**RE: Mesa Del Sol Self Storage
5500 Turing Dr. SE
Grading and Drainage Plan
Engineer's Stamp Date: 5/7/2025
Hydrology File: R16DA1004**

**Re: Mesa Del Sol Self Storage
 5500 Turing Dr. SE
 Grading and Drainage Plan
 Engineer's Stamp Date: 01/15/2025
 Hydrology File: R16DA1004**

Here are the responses to the comments provided on March 21, 2025 in regards to an **Updated Grading & Drainage prior to continuing onsite grading and foundation work.**

SHEET NUMBER: **C-1.0**

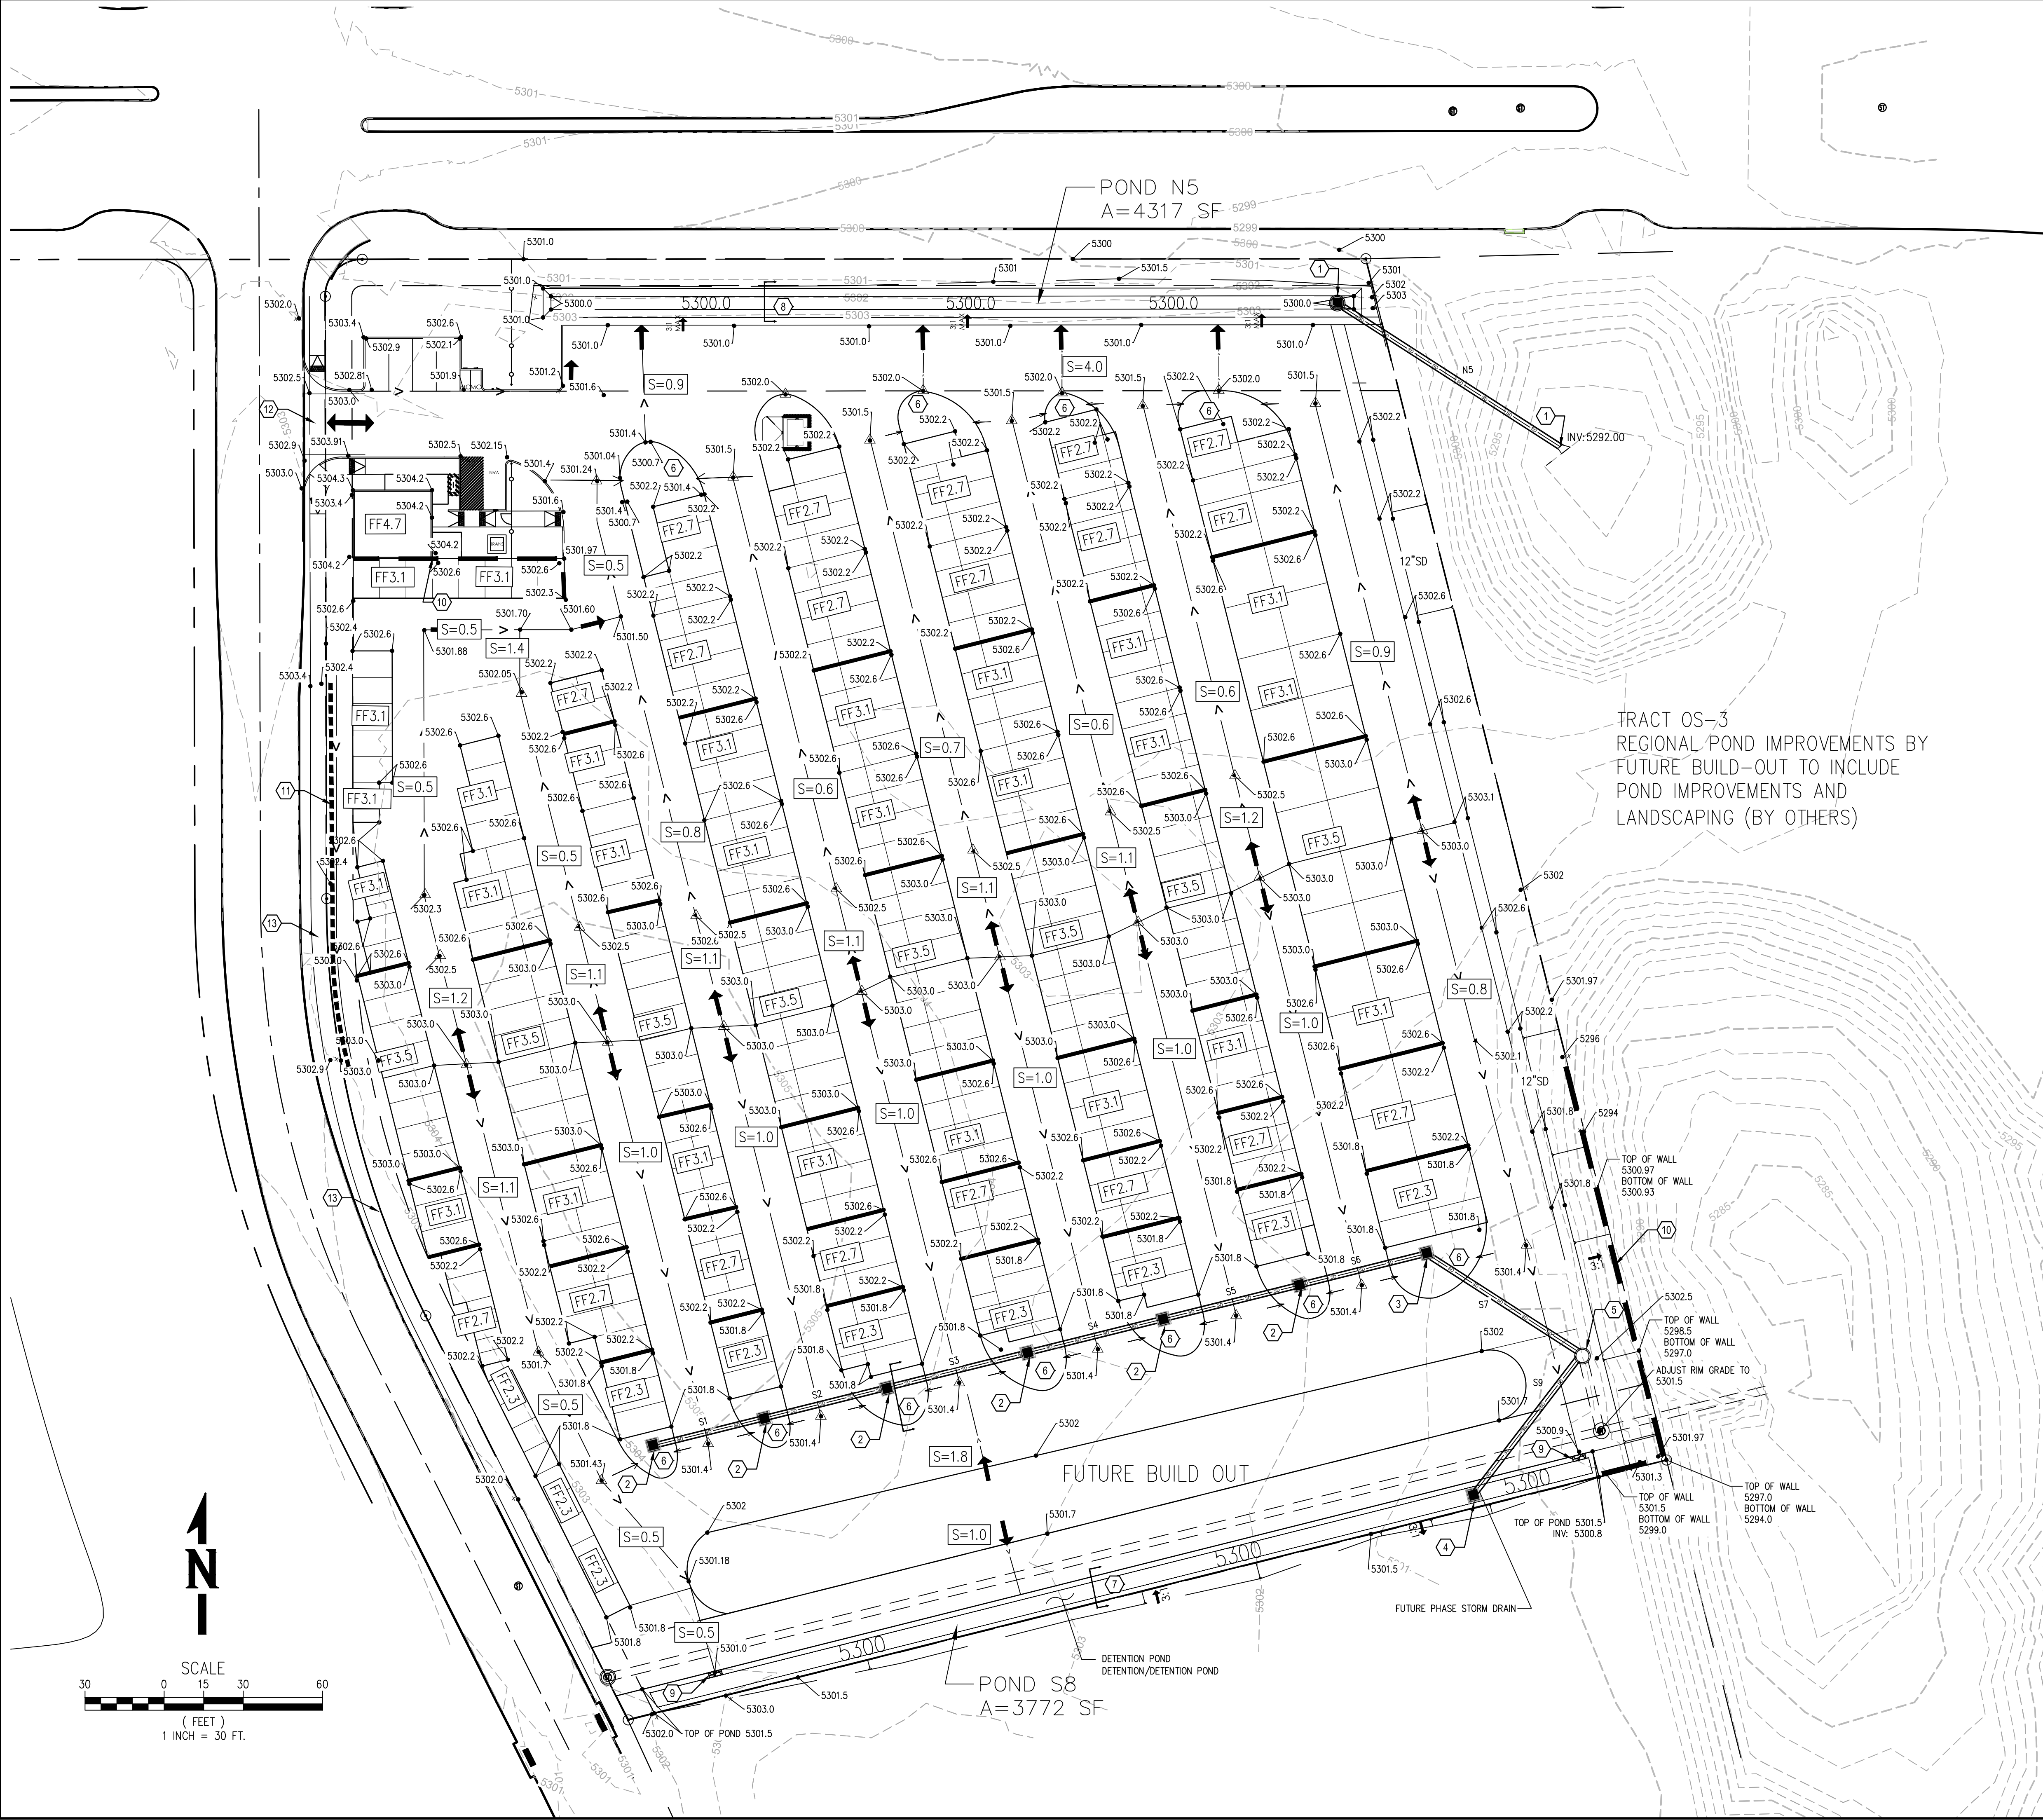
1. Removal of grading and fill material covering the outlet to an existing 36-inch pipe which is designated as roadway drainage from Touring Rd.
Response: Concur. See revised Grading Plan for call out.

3. Most importantly, provide documentation allowing the use of and filling in the existing retention pond was promised months ago and has yet to be received by the CABQ, and include references to said documentation on the Updated Grading & Drainage Plan.
Response: There is no intend to use the existing retention pond material to use for filling of onsite construction, OS3 pond will be graded per revise Grading Plan C-1.0.

10. Show all portions of proposed retaining walls on the property of the project.
Concur. Please see revised grading plan for proposed garden wall locations, retaining wall eliminated per revised Grading Plan C-1.0.

11. The existing ponds should be completely developed for the 100-year 10-day storm and associated capacity, together with slope erosion protection and access barricades where needed.
Concur. See revised Grading Plan C-1.0 for existing pond improvement with pond capacity, erosion protection has been added to west side of pond per COA Section 1013 Slope Stabilization and Seeding on 3:1 slope.

12. Per follow up phone conversation on 4/29/2025, COA hydrology had requested to add access road to existing pond.
Concur. See revised Grading Plan C-1.0 for access road design into Tract OS-3 pond bottom.
